30 April 2012.

STATEMENT OF ENVIRONMENTAL EFFECTS: SECTION 75W APPLICATION, MODIFICATIONS TO MAJOR PROJECT MP NO.10_0158 (BUILDINGS 7 AND 8) – 61 MOBBS LANE, EPPING

- Furniture layout shown indicative only.
- Site and Landscape shown for context only. Refer to Landscape Drawings .

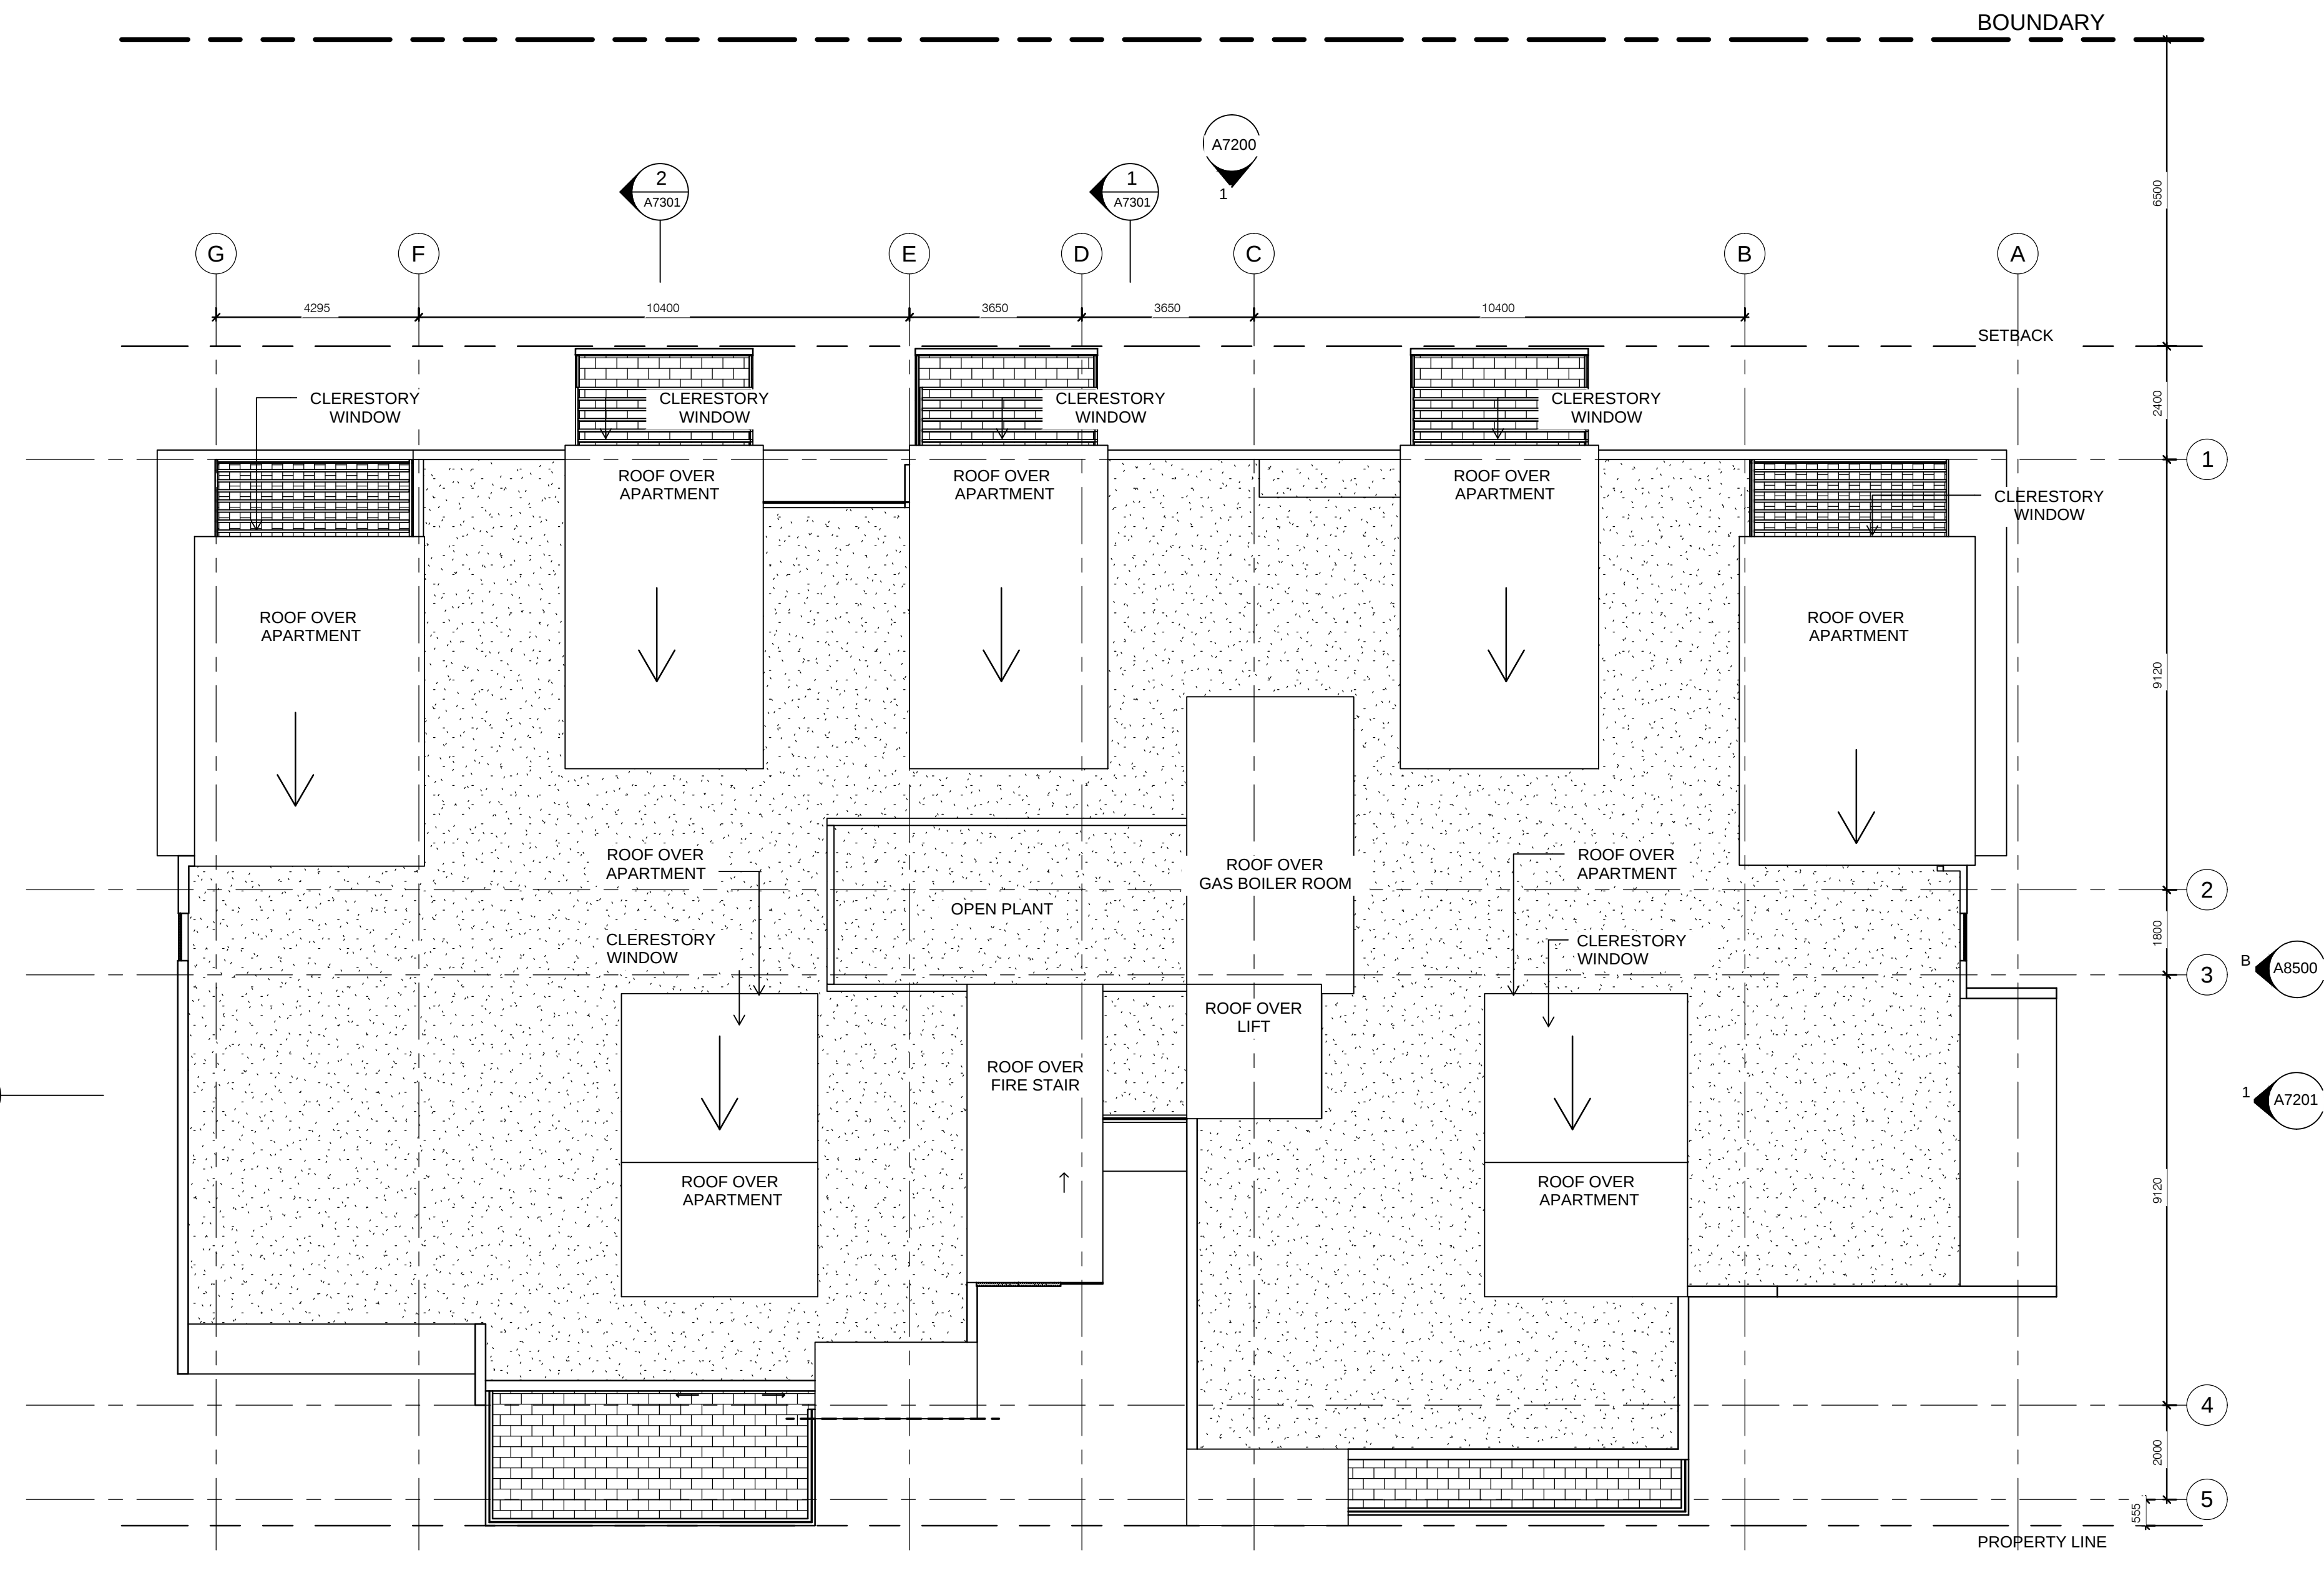
A number of windows need to be relocated for structural reasons. The windows need to be moved along the same wall and at the same height. There is no other change to the size of the window, it is the same window, just re-positioned.

In Building 7 Units 101, 201, 301, 401, 501 are affected by the window repositioning.

Portions of the wall have been replaced with glass to create an architectural feature and more importantly to allow more light into the living rooms. The glazing modifications are identified as number 2, on the Architectural Plan key.

In Building 7 Units G07, 107, 207, 307, 407 and 507. The impact of which is shown on the East Elevation of Building 7. There are no modifications of this nature applicable to Building 8.

1 BUILDING 8 LEVEL 5 PLAN
1 : 100

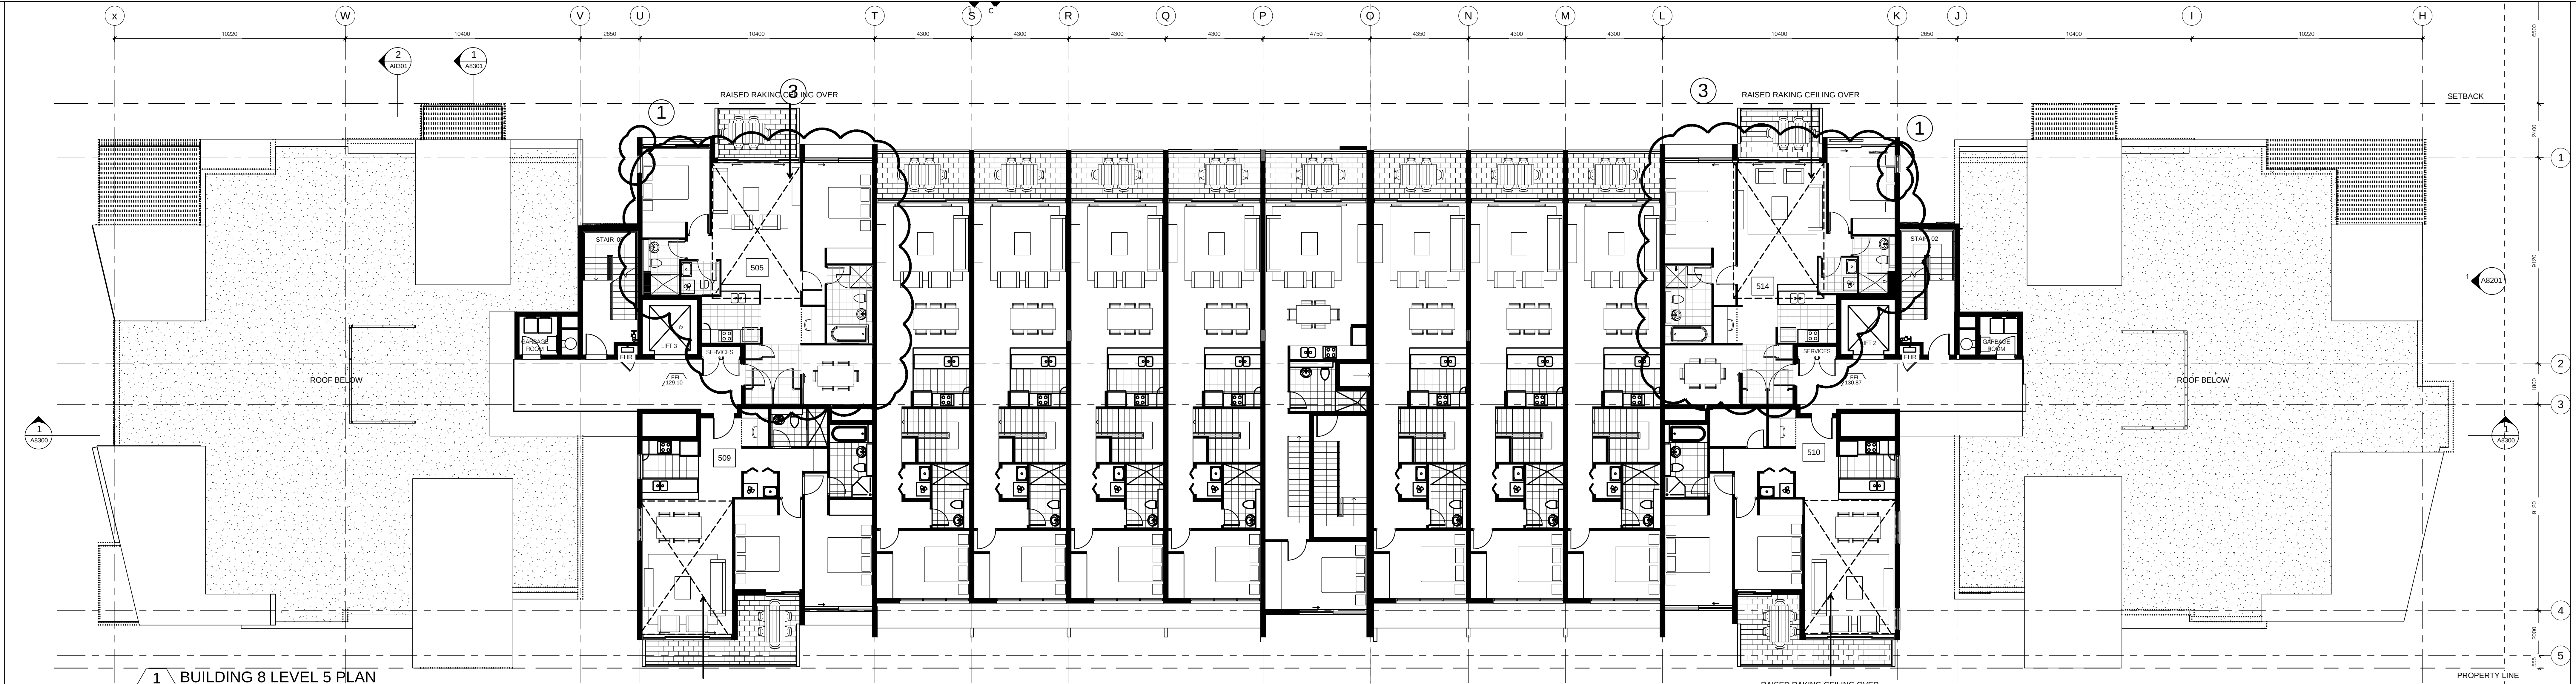
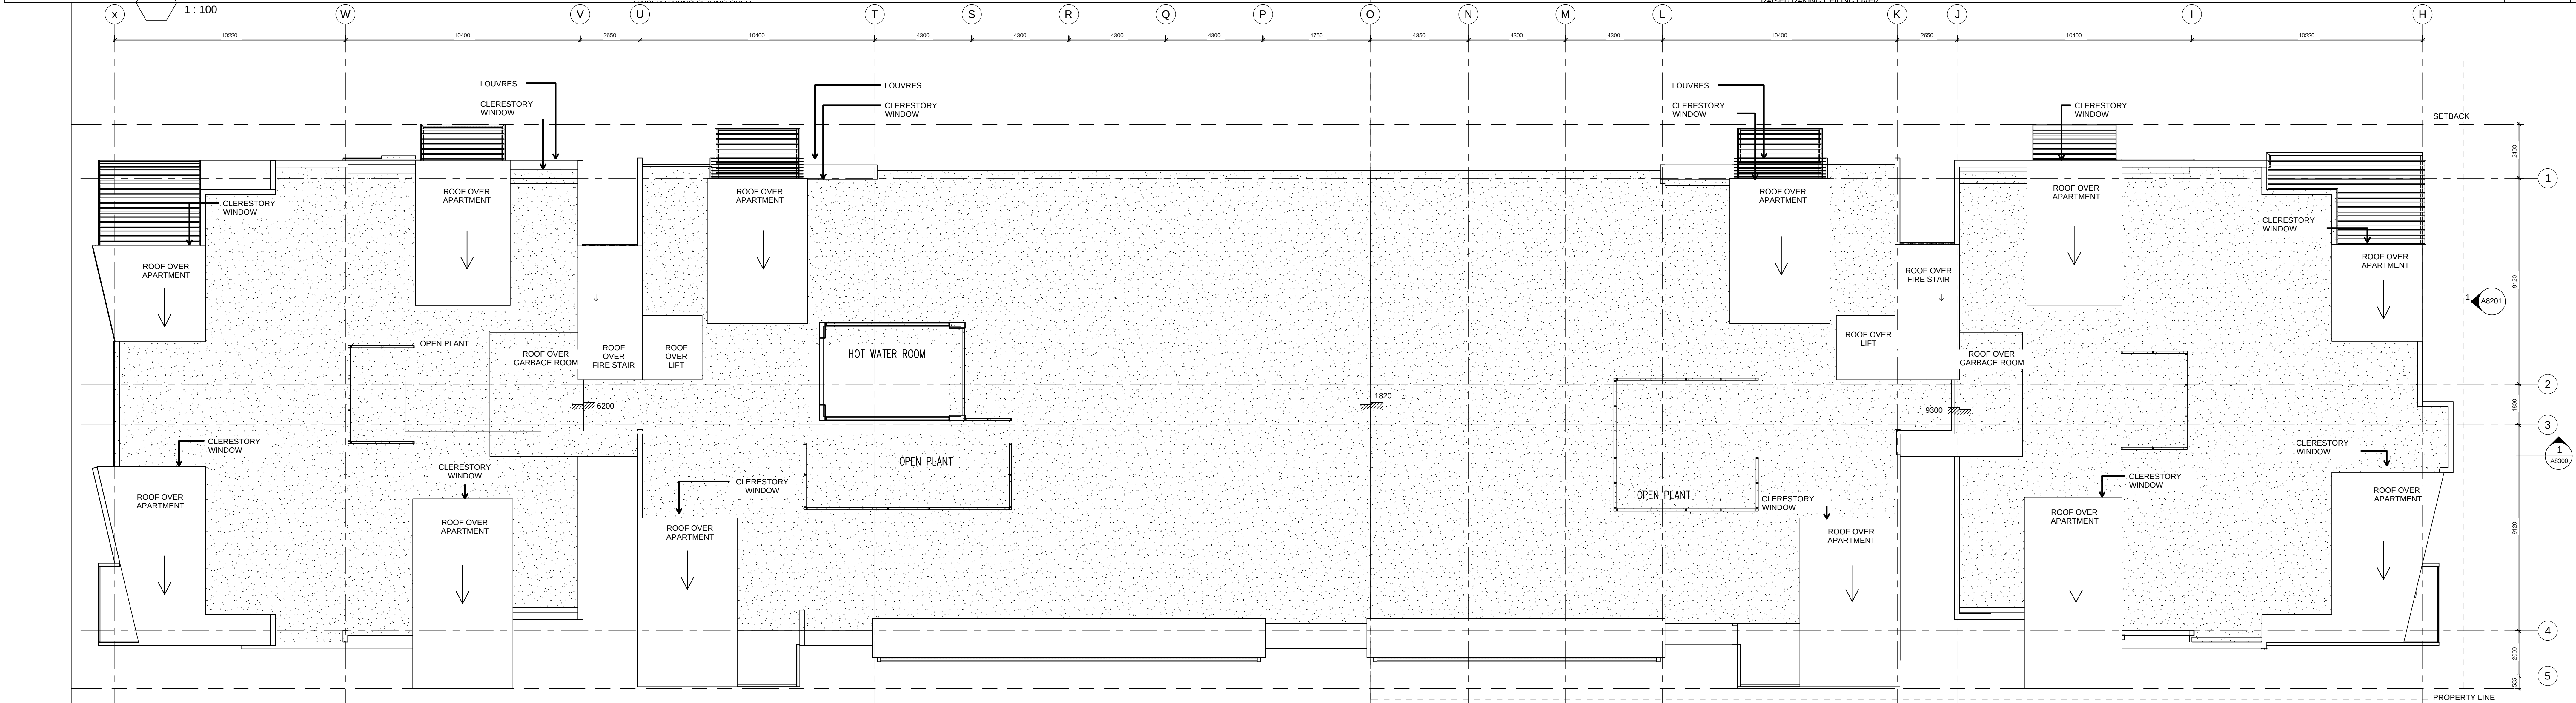
In Building 8 Units 111, 101,120, 208, 201, 215, 304, 305, 314, 401, 407, 505 and 514 are affected by the window repositioning.

In Building 8 a number of the units have been re-configured. Previously a portion of the internal space was used as a corridor, the modifications simply activate this dead space. The updated layouts turn a passive area into a useable area by providing more amenity into the unit. The dining rooms now extend into a portion of that space. The layout modification are identified, with the number 3, on the Architectural Plan key. Units 101, 120, 305, 314, 505, 514 have been updated. There are no modifications of this nature applicable to Building 7.
